POST EPC MEMORANDUM

RE: PR- PR-2018-001482, SI-2023-01925–Site Plan-EPC _ Riverside Mobile Home Park

The agent (Tierra West) for Riverside West, LLC., has worked with Staff to fulfill post EPC requirements to meet Conditions of Approval, 1-11 for the Riverside Mobile Home Park, Site Plan-EPC, zoned R-MC; located at 211 Ervien Ln SW, northwest of the intersection of Ervien Ln and Coors Blvd. See EPC Notice of Decision (NOD) dated January 18, 2024.

ENGINEER'S SEAL

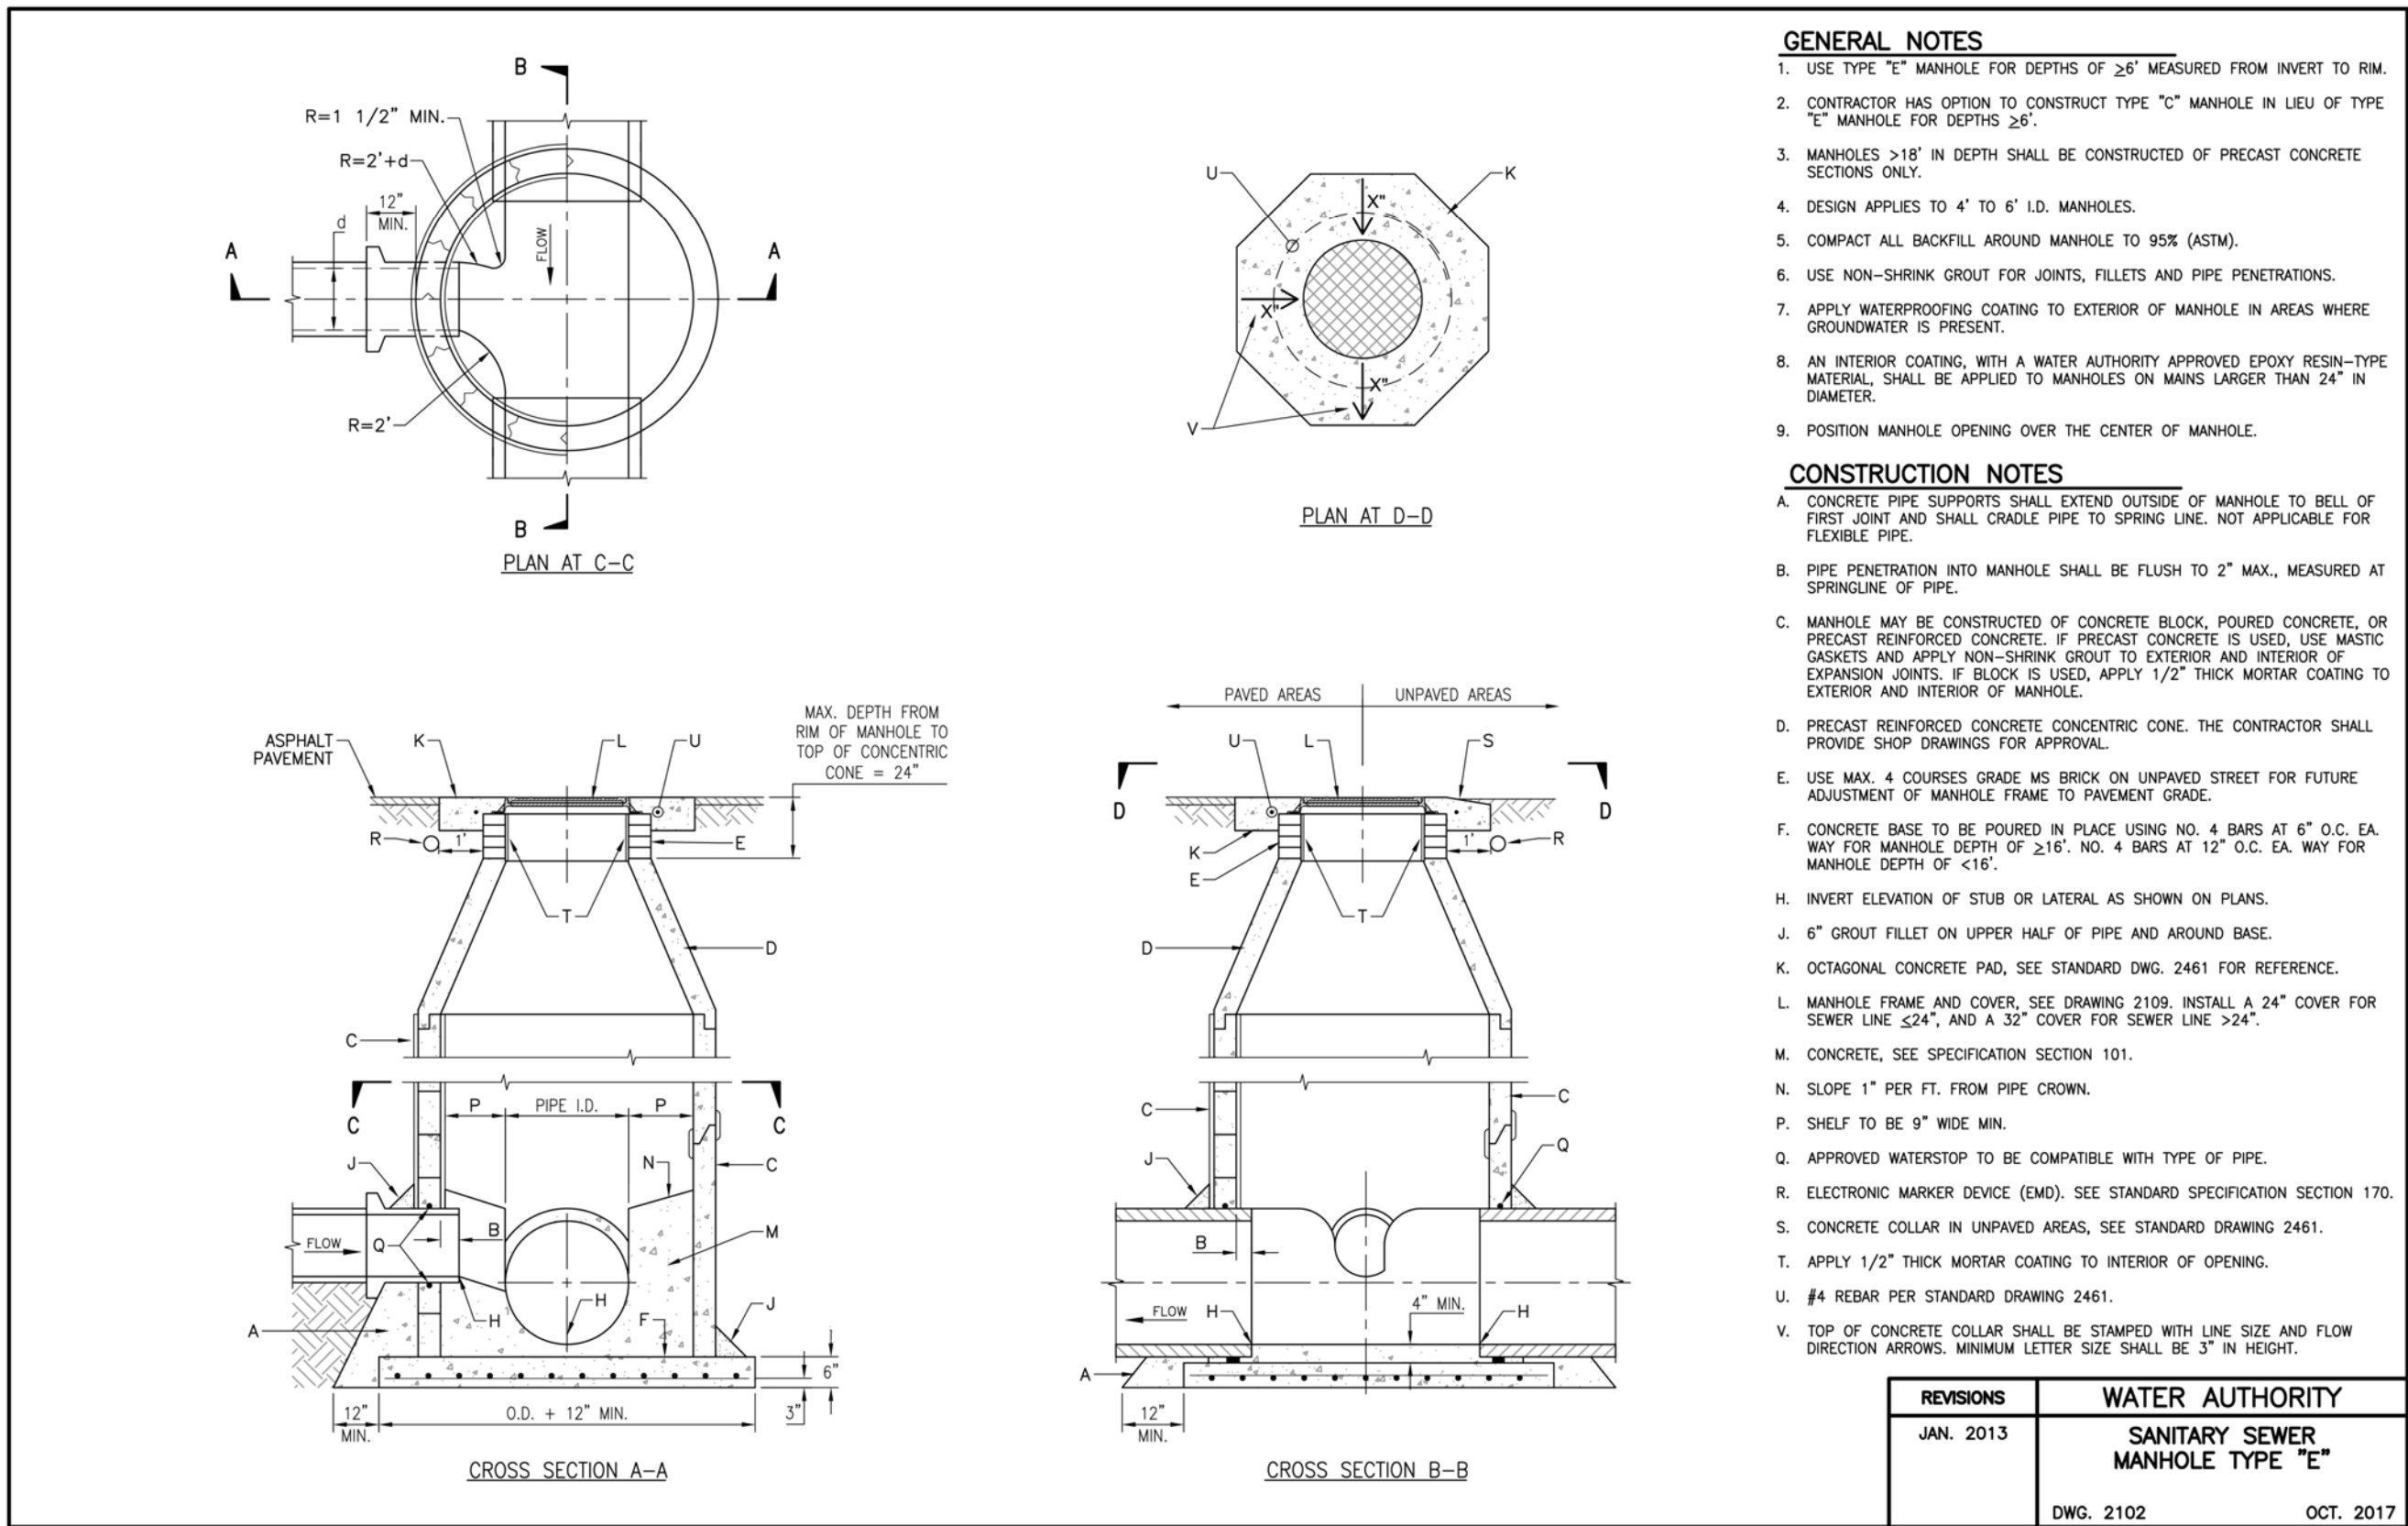
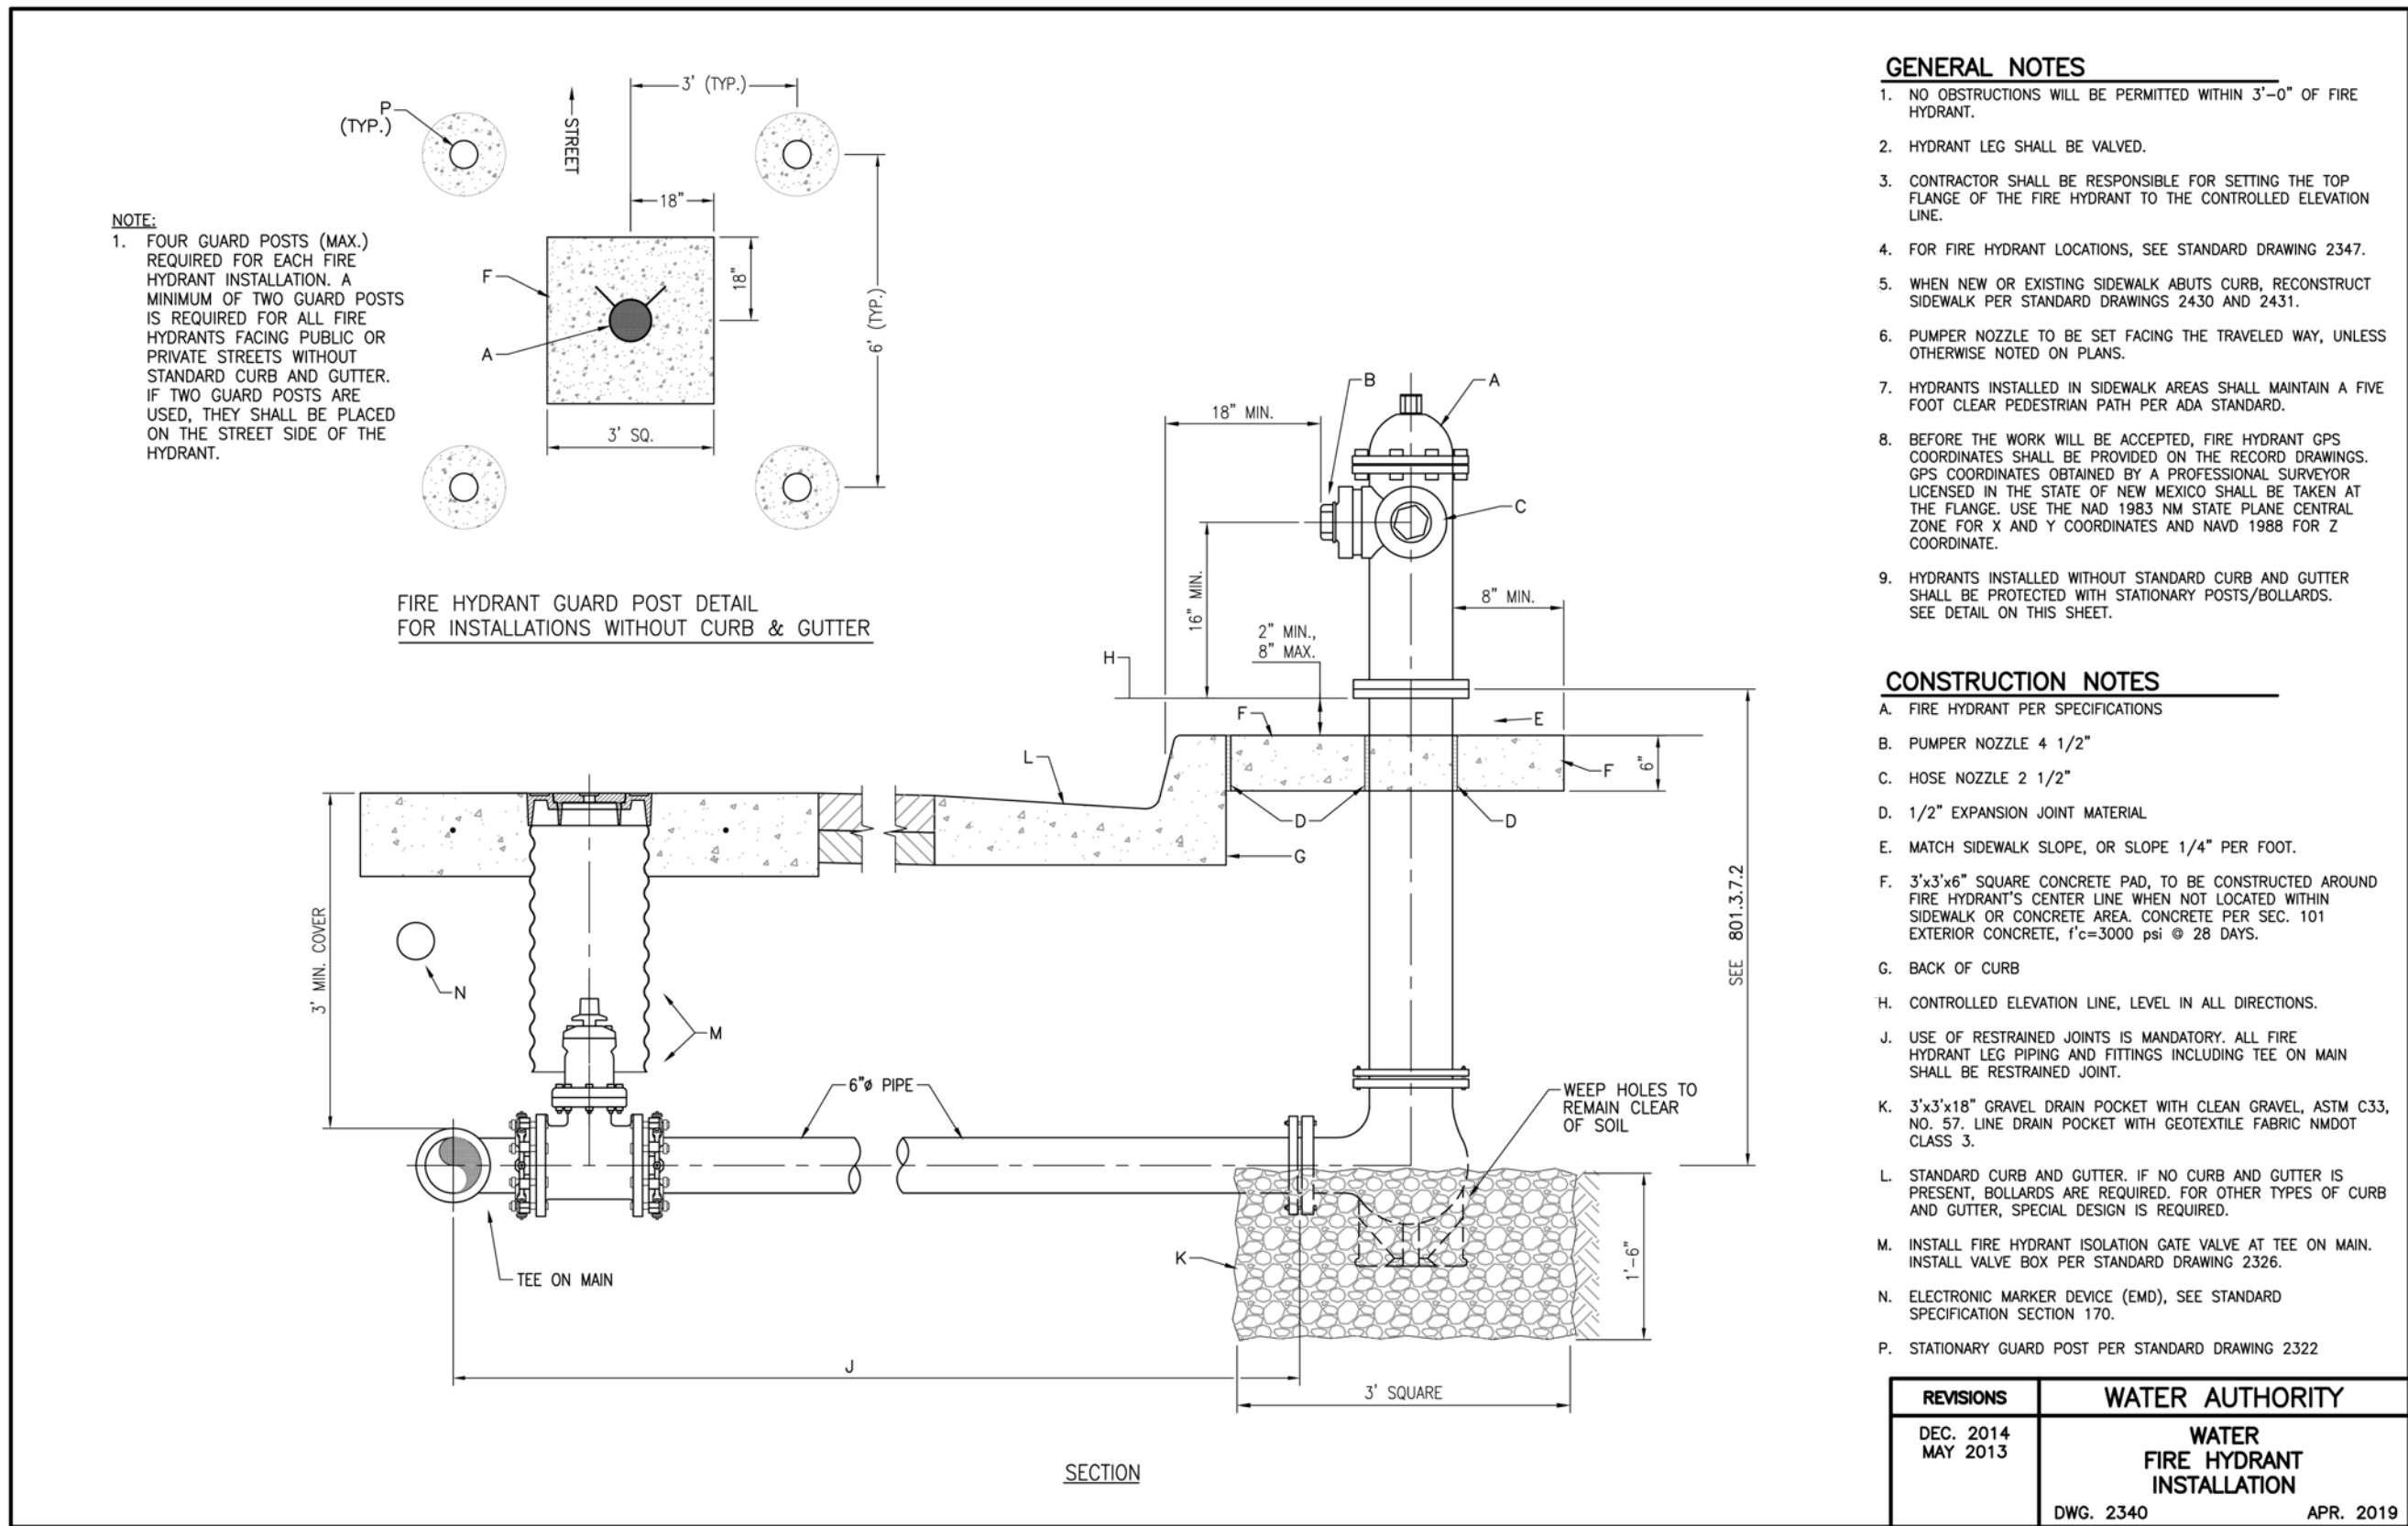
3. Condition 3a has been partially satisfied. Note number 3 has not been changed to reflect the light pole maximum of 16' as shown on Detail Sheet C5.0. Keyed Note number 7 has been changed to reflect this condition.

5. Condition 5 has been met. Conceptual Grading and Drainage Plan has updated text to use "City of Albuquerque" instead of Rio Rancho.
6. Condition 6 has been partially met and replaced with a standard 16' max light pole detail on sheet C5.0. The note, "within 100' of Residential" was not added to the max light pole detail.
